KITTITAS COUNTY

MEMORANDUM

SUBJECT: Sunny Sage Short Plat SP-10-00006

Our department has reviewed the short plat application and has the following comments:

SUNNY SAGE SHORT PLAT

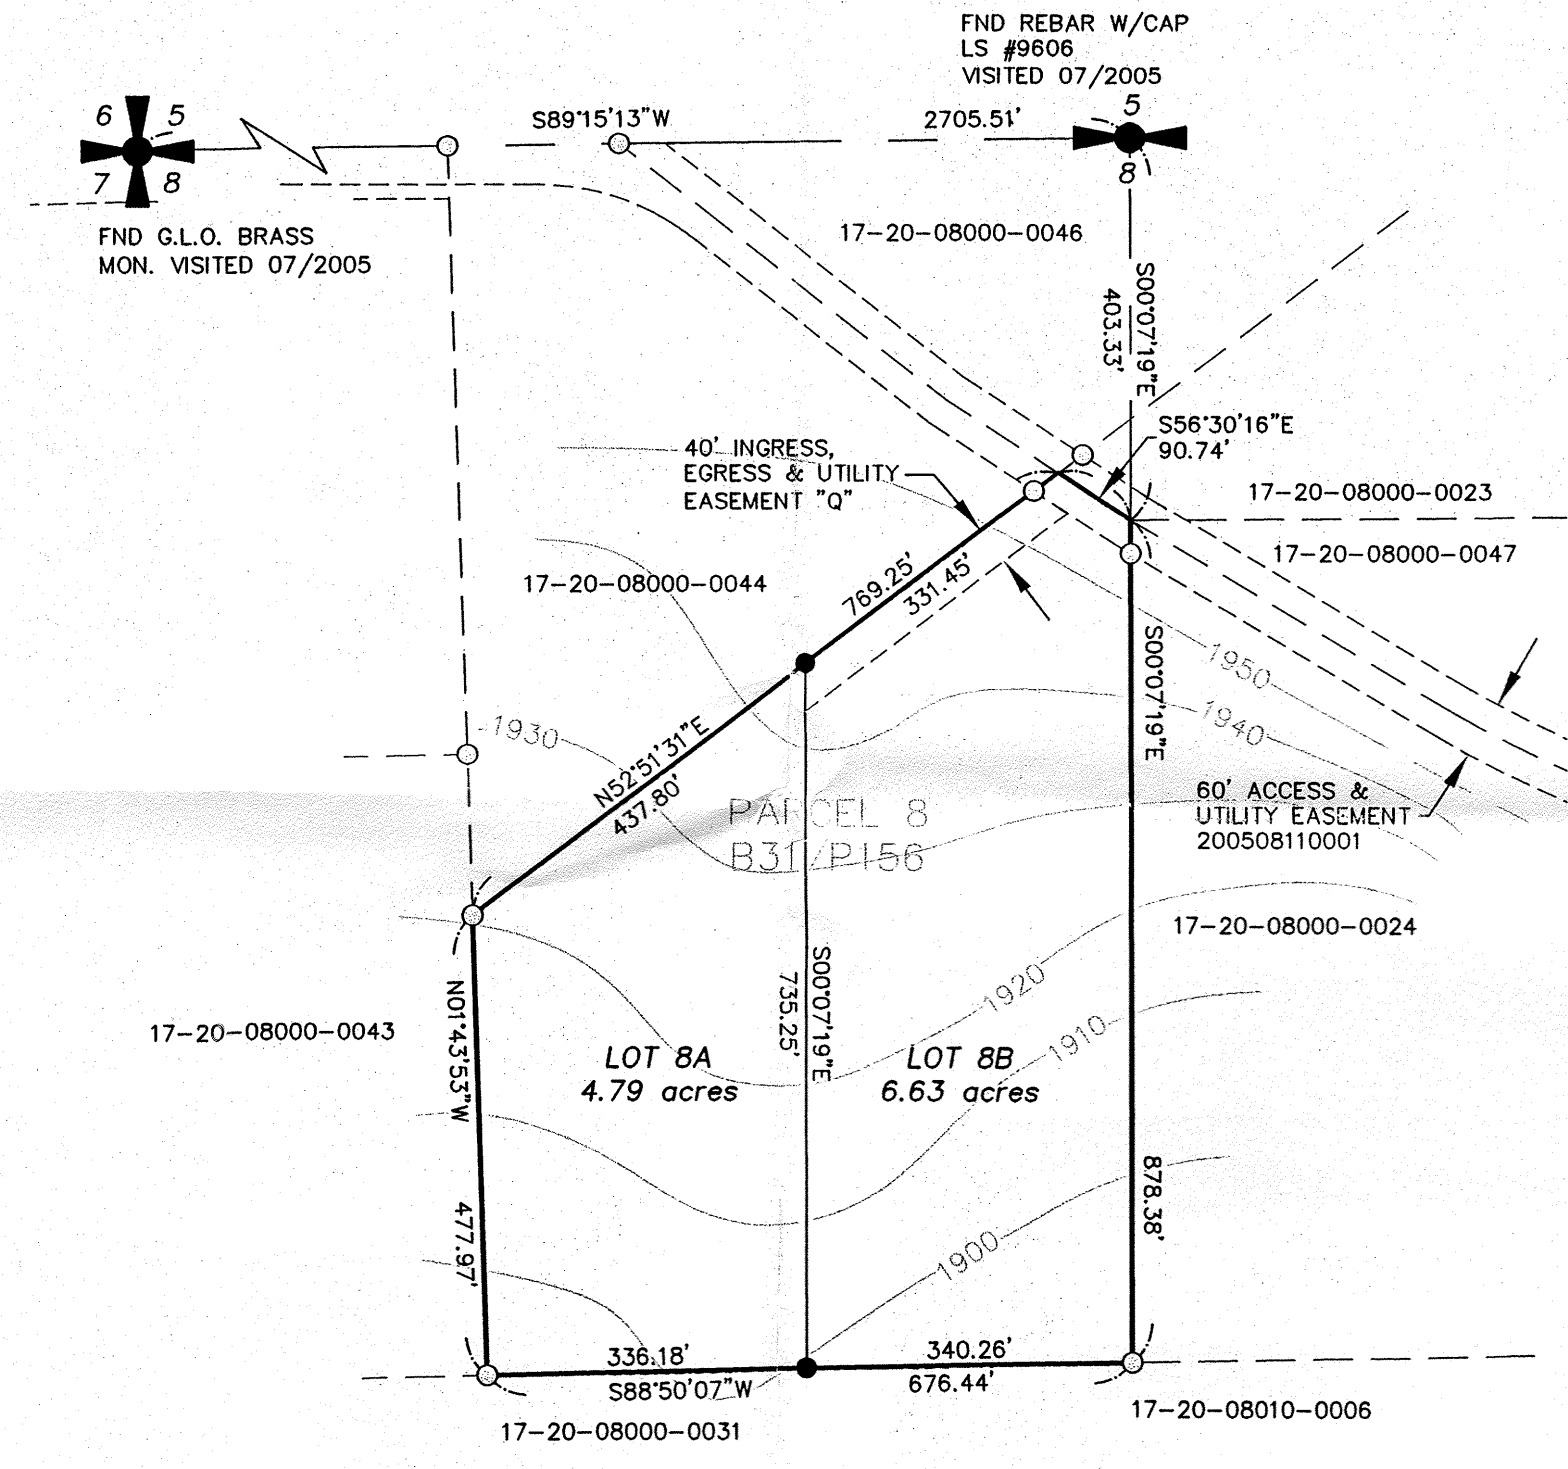
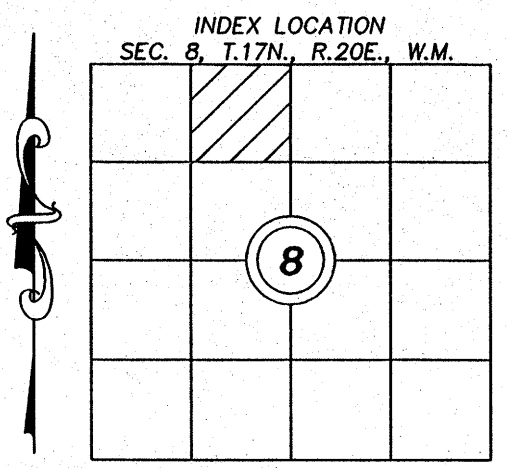
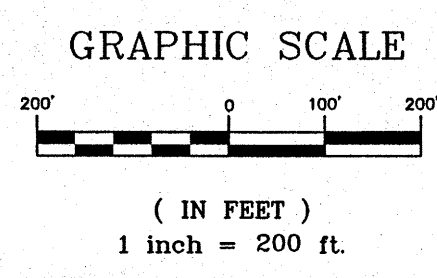
4. Access to Clerf Road: The entire easement to Clerf Road shall be shown. The easement may be shown in the vicinity map if clearly labeled.

5. Turnaround: A hammerhead or cul-de-sac shall be constructed at the closed end of all dead-end roads serving 3 or more lots. The turnaround shall be located at the intersection of the 60' access easement and easement 'Q'. Hammerheads and cul-de-sacs shall conform to the requirements specified by the 2006 International Fire Code. Contact the Fire Marshal regarding any additional cul-de-sac requirements.
